Springwell Solar Farm

Response to Deadline 2 Submissions

EN010118/APP/8.21
August 2025
Deadline 3
Springwell Energyfarm Ltd

Figure 2: Indicative Construction Timelines of all NSIPs and Major Development Schemes Considered for Potential Interrelationships

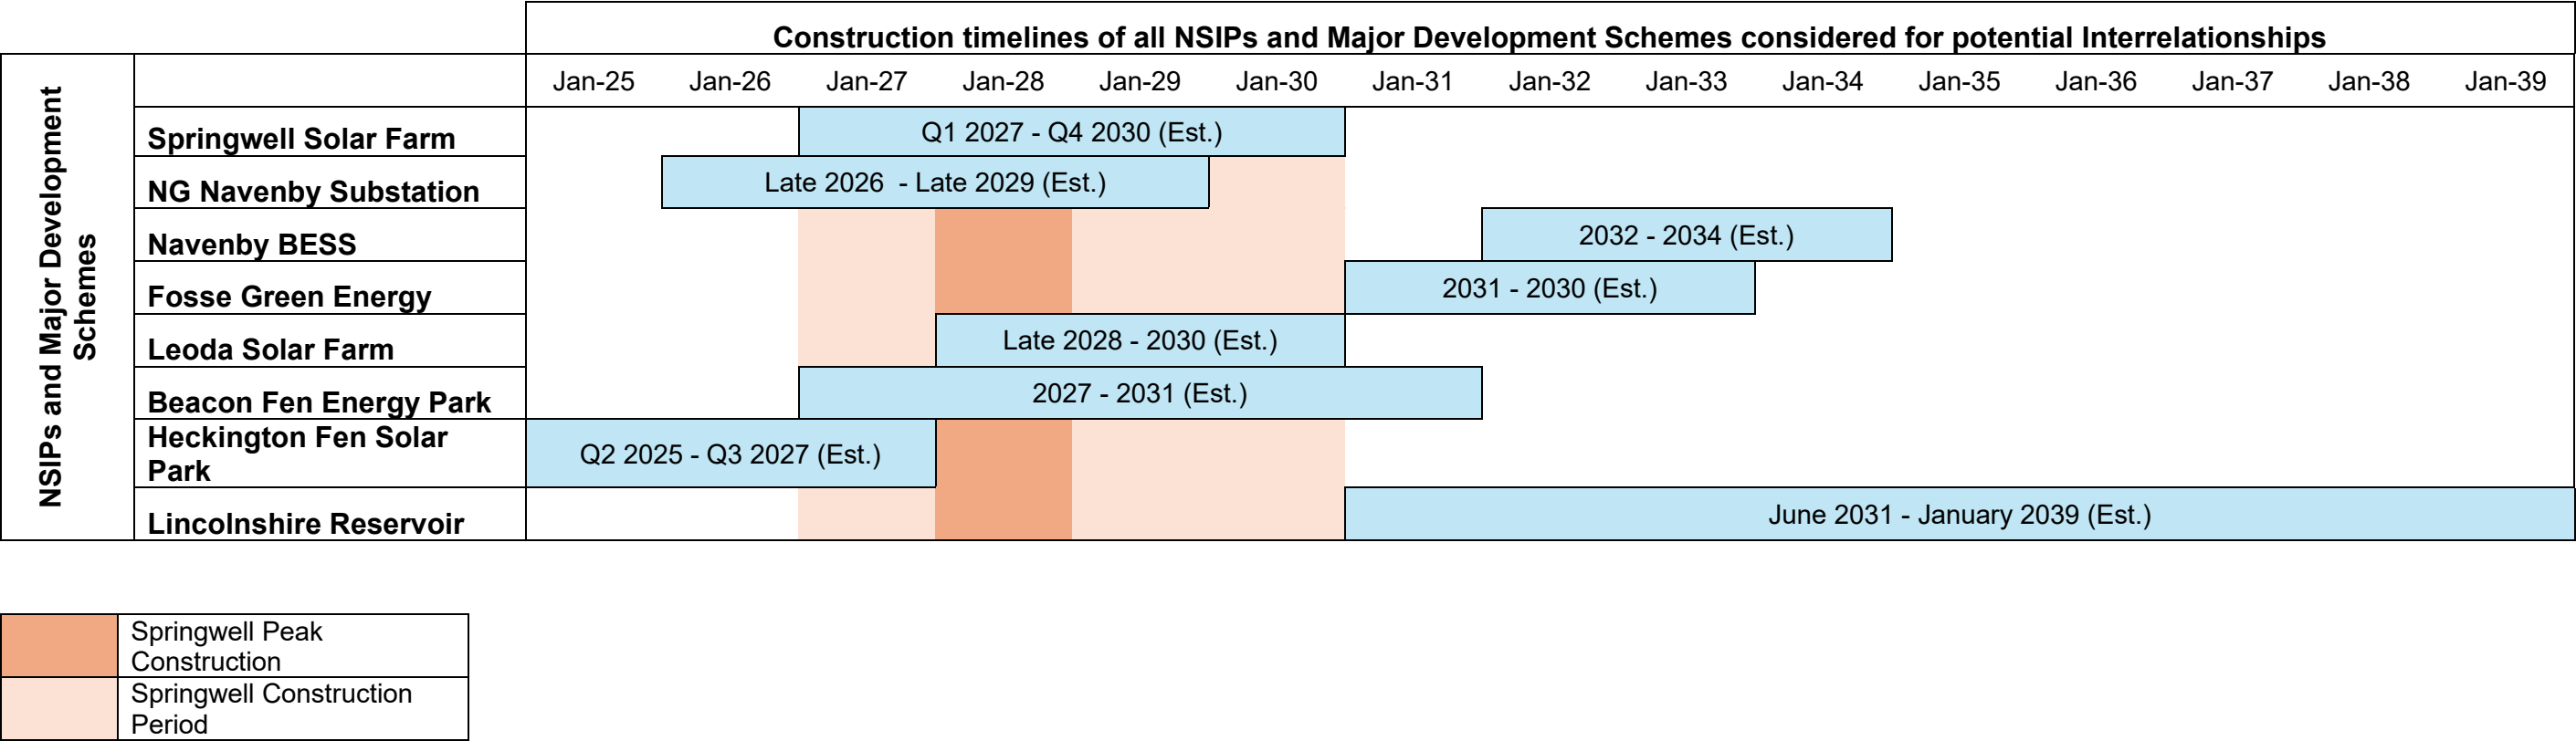
LCC further disagrees with the Applicant's assertion that interrelationships between Springwell and other projects "are not anticipated", especially when five other schemes are under construction during the same period, with three of those overlapping Springwell's peak construction phase (as shown in figure 2 of the submitted document).

The Applicant has reviewed Lincolnshire County Council's submission at Deadline 2 **[REP2-025]** regarding the **Interrelationships with other Nationally Significant Infrastructure Projects and Major Development Schemes [EN010149/APP/8.11] [REP1-068]** and will incorporate the Council's feedback where appropriate. As discussed in the ISH 3 hearing and documented in the **Written Summary of Oral Submissions at Issue Specific Hearings 2, 3 and 4 [EN010149/APP/8.22]**, the Applicant will share an updated draft with both LCC and NKDC before submitting the next version of the Report at Deadline 4 to ensure agreement on the approach and updates.
